A1 in Northumberland
National Infrastructure Planning
The Planning Inspectorate
Temple Quay House
Bristol
BS1 6PN

Application by Highways England for an Order Granting Development Consent for the A1 in Northumberland – Morpeth to Ellingham

Deadline 9 – 15 June 2021

General Arrangement Plans (Ref: REP8a-002):

Drawing Number	HE551459-WSP-GEN-A2E-DR-CH-02406	Revision	3
		PW Stage Code	0

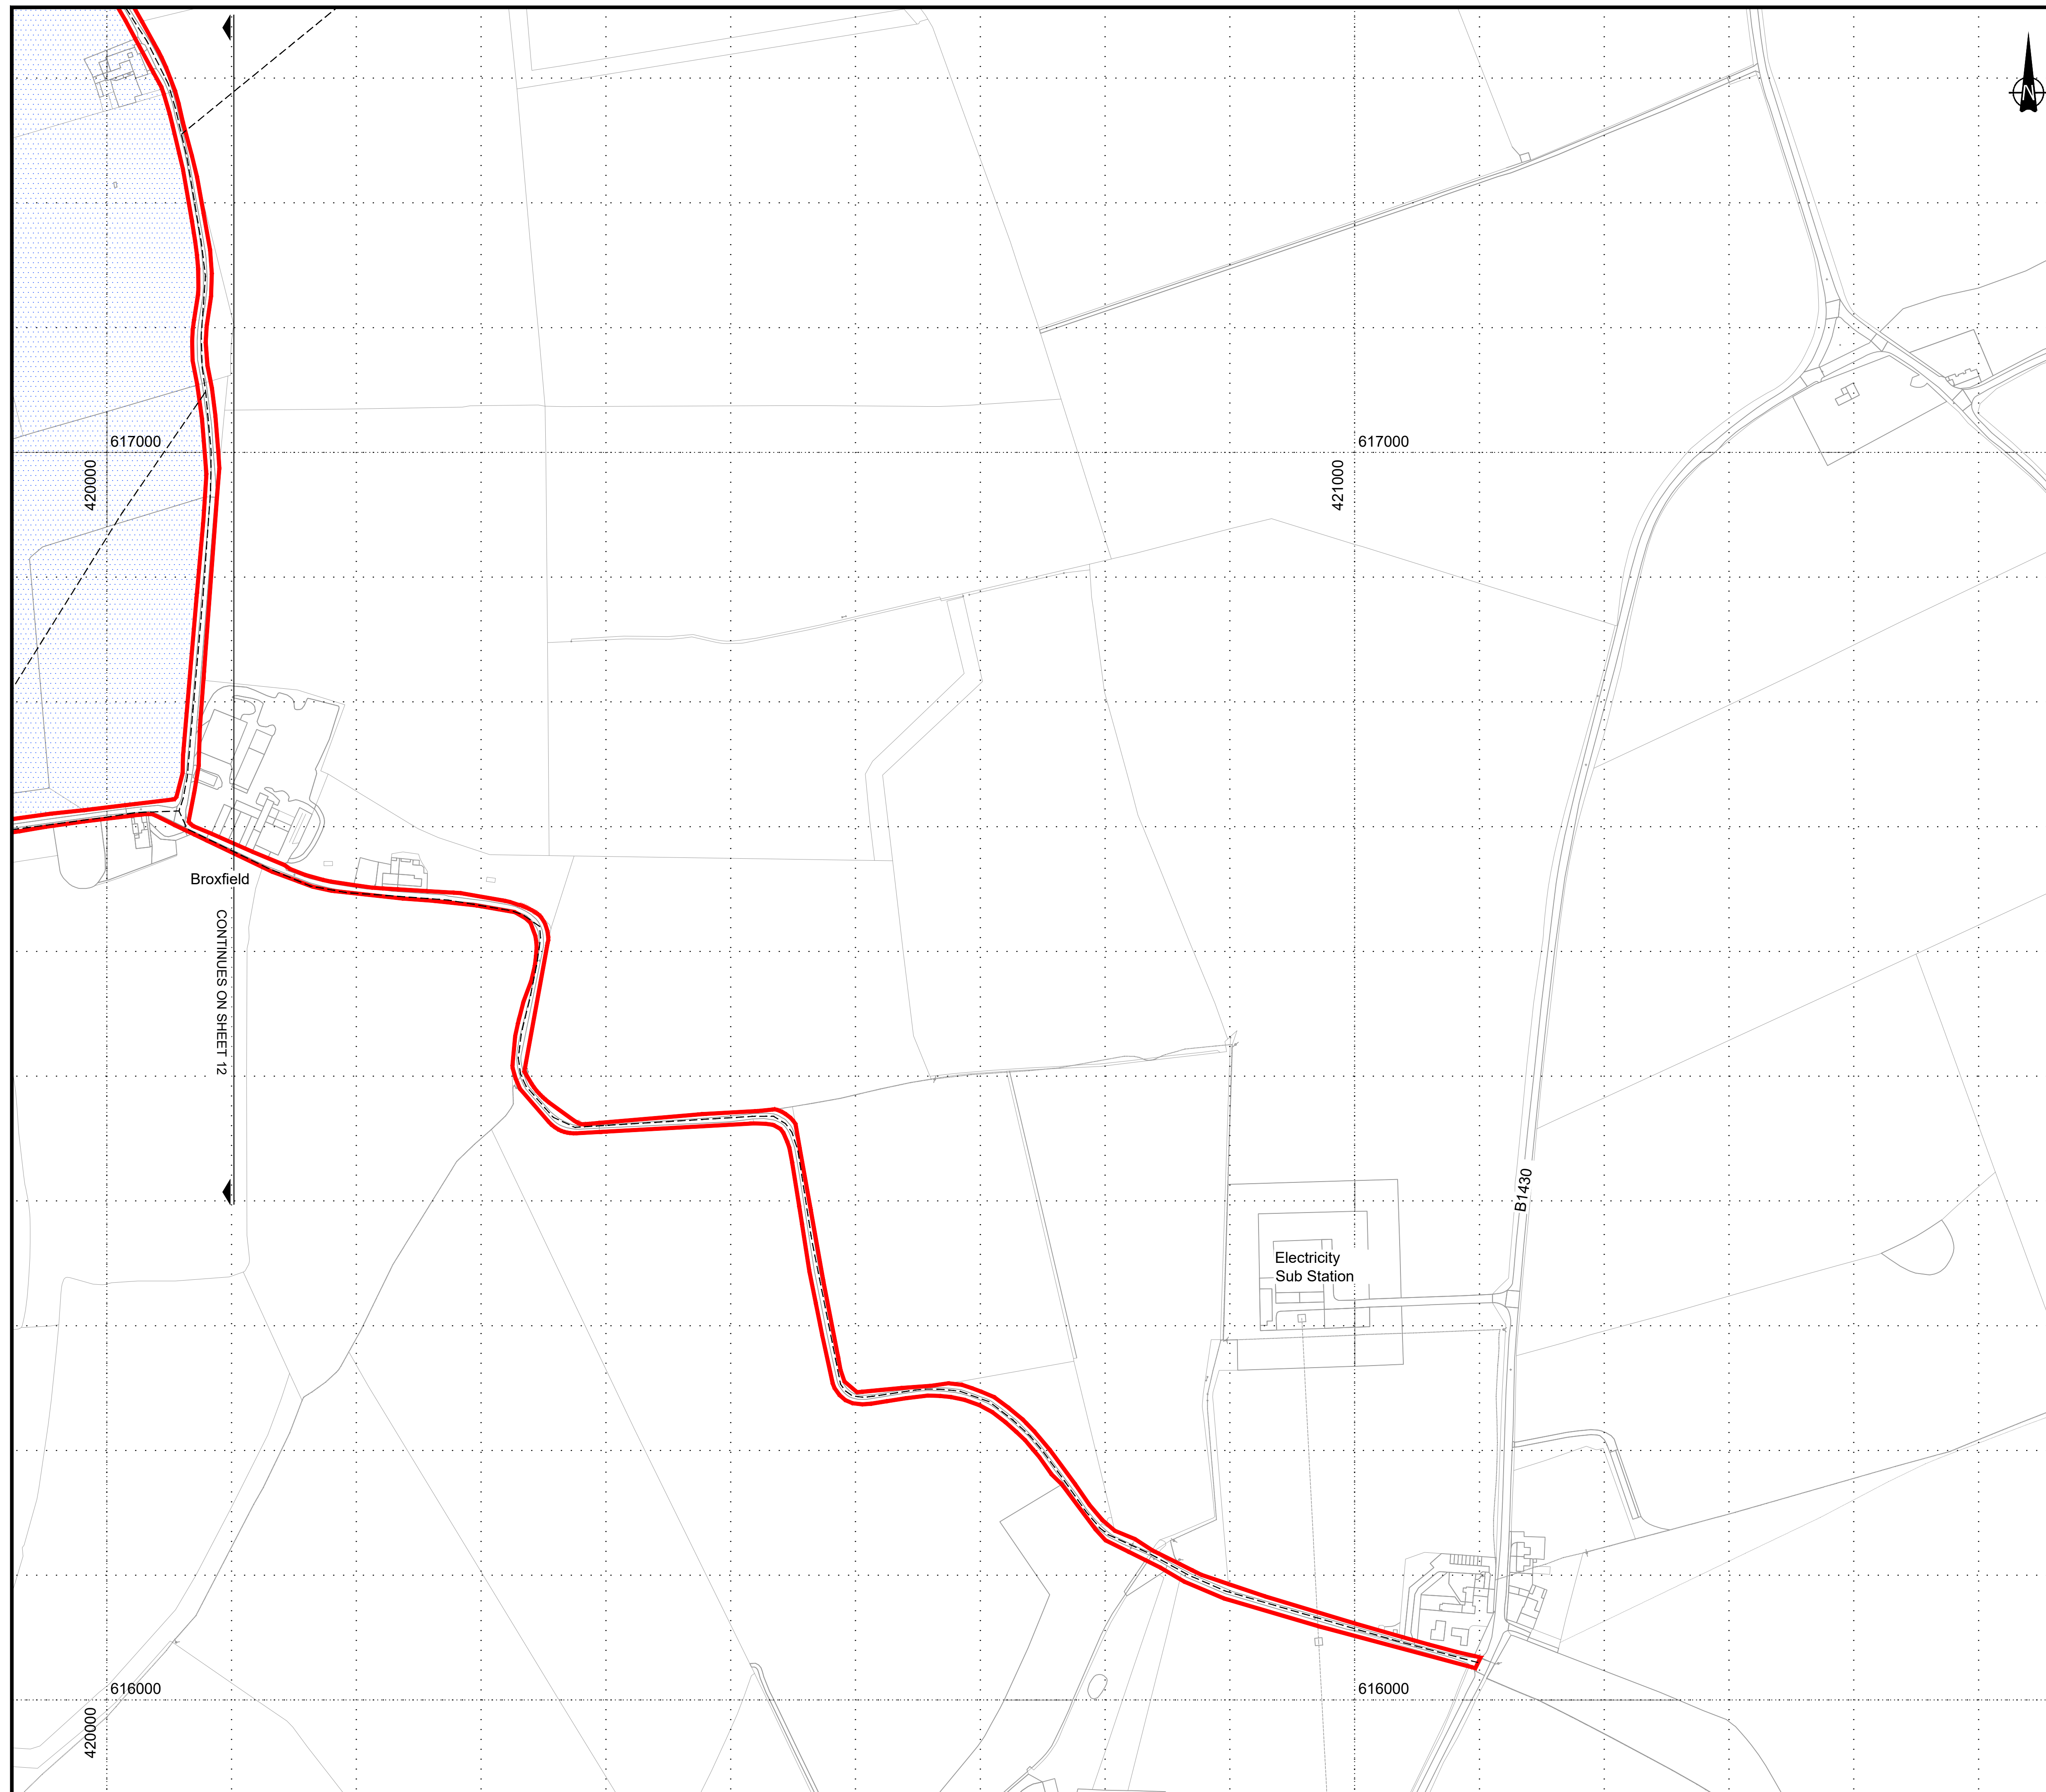
- This revision of the General Arrangement Plans shows the remaining omission in respect to the East Linkhall Road proposals and includes the turning head at the end of the new Local Road Network which is acceptable subject to the detailed design process to be undertaken after the Examination and confirmation from the applicant regarding the existing status of the highway to the north of the turning head.
